D. J. Halpenny & Associates Ltd.

File: 117-668

**RE: BLACK SHEEP DEVELOPMENT – 2159 Mer Bleue Road
Traffic Comment**

FIGURE 2.2
CONCEPTUAL SITE PLAN

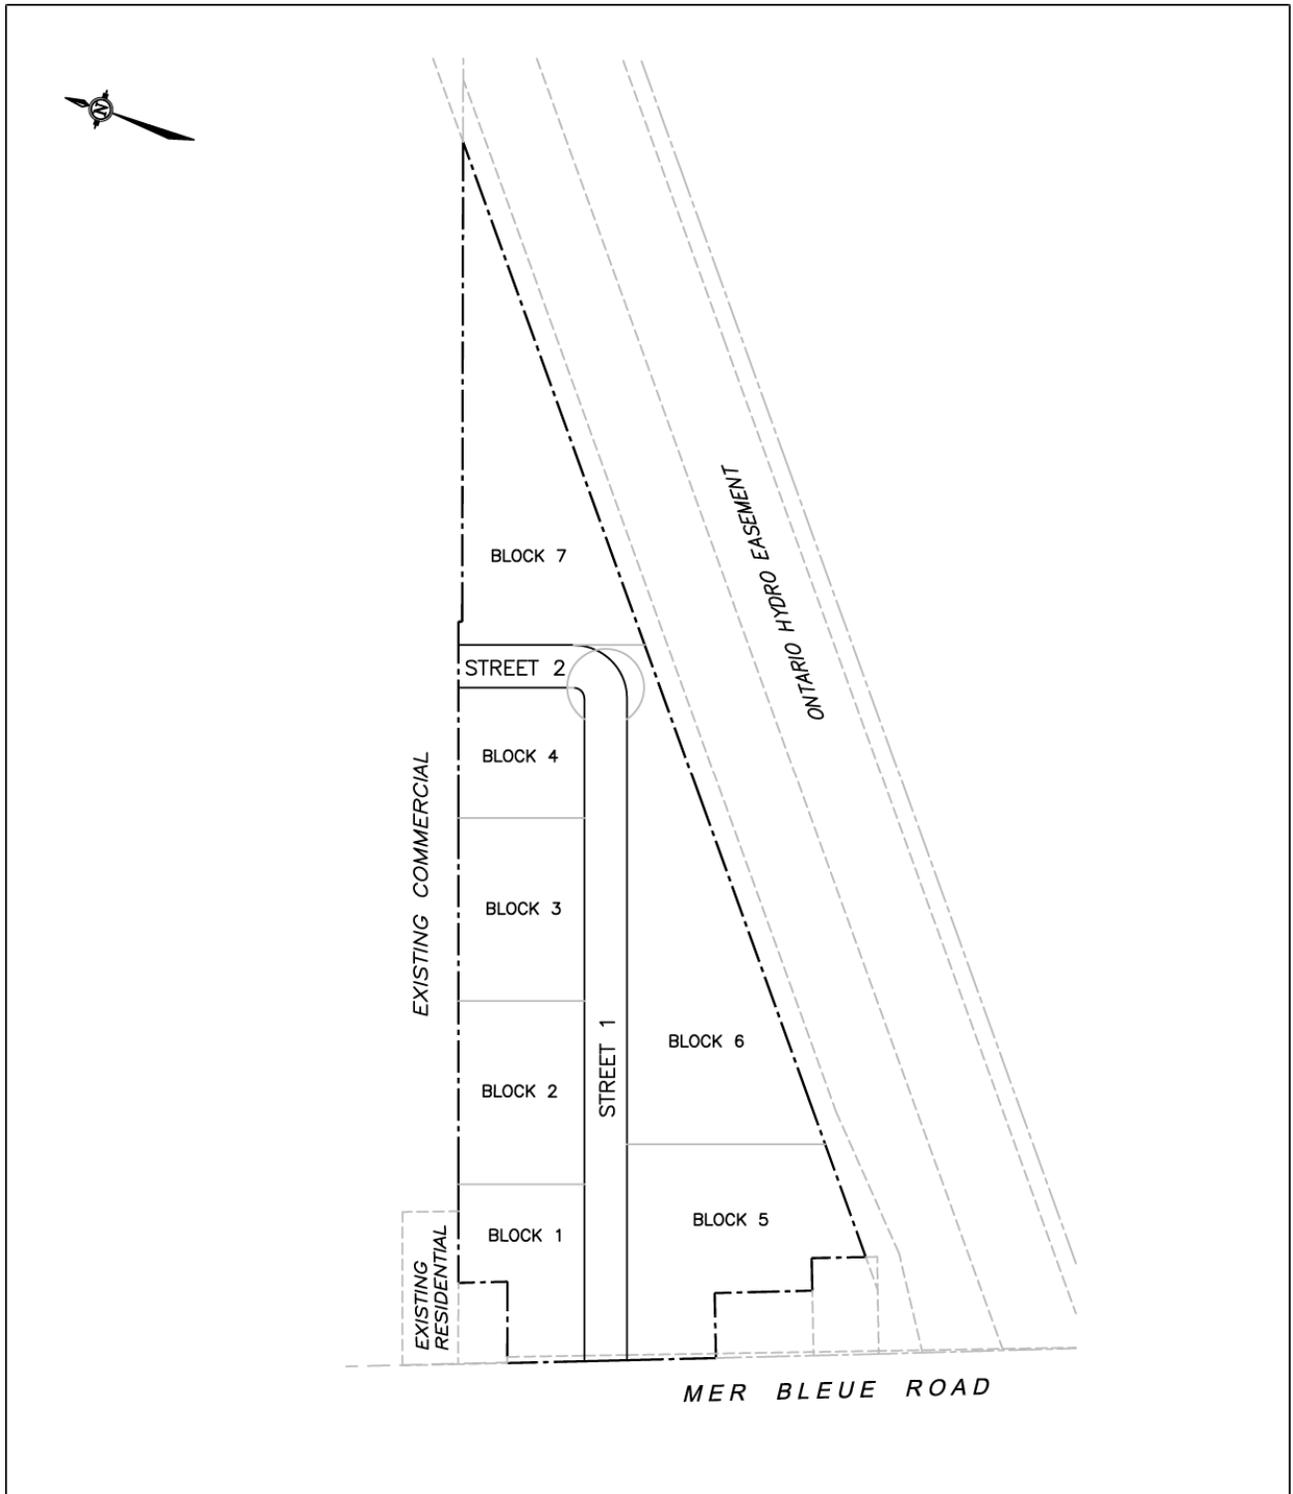
This letter is in response to the transportation comment relating to Street 1 in the Black Sheep Development being too long for a cul-de-sac. I have neither heard nor come across any transportation related guidelines which address the length of a road with a cul-de-sac. The approval of a road with a cul-de-sac is dependent on the traffic generated by development along the road, and the operation of the intersection of the road and the connecting road. The TIA study did determine that the intersection of Street 1 and Mer Bleue Road would operate at an acceptable level of service. Emergency access to the development is also a determining factor for the approval of roads with cul-de-sacs and only one access point.

There are many municipal roads within the City of Ottawa and adjacent municipalities which have cul-de-sacs and are longer than Street 1 which will be approximately 300 m. A major point to keep in mind is that Street 1 with a cul-de-sac is a temporary roadway design plan. As development progresses and Vanguard Drive is extended further west to Mer Bleue Road, Street 1 will be extended to connect to Vanguard Drive. This would eliminate the cul-de-sac and provide two access points to development along Street 1.
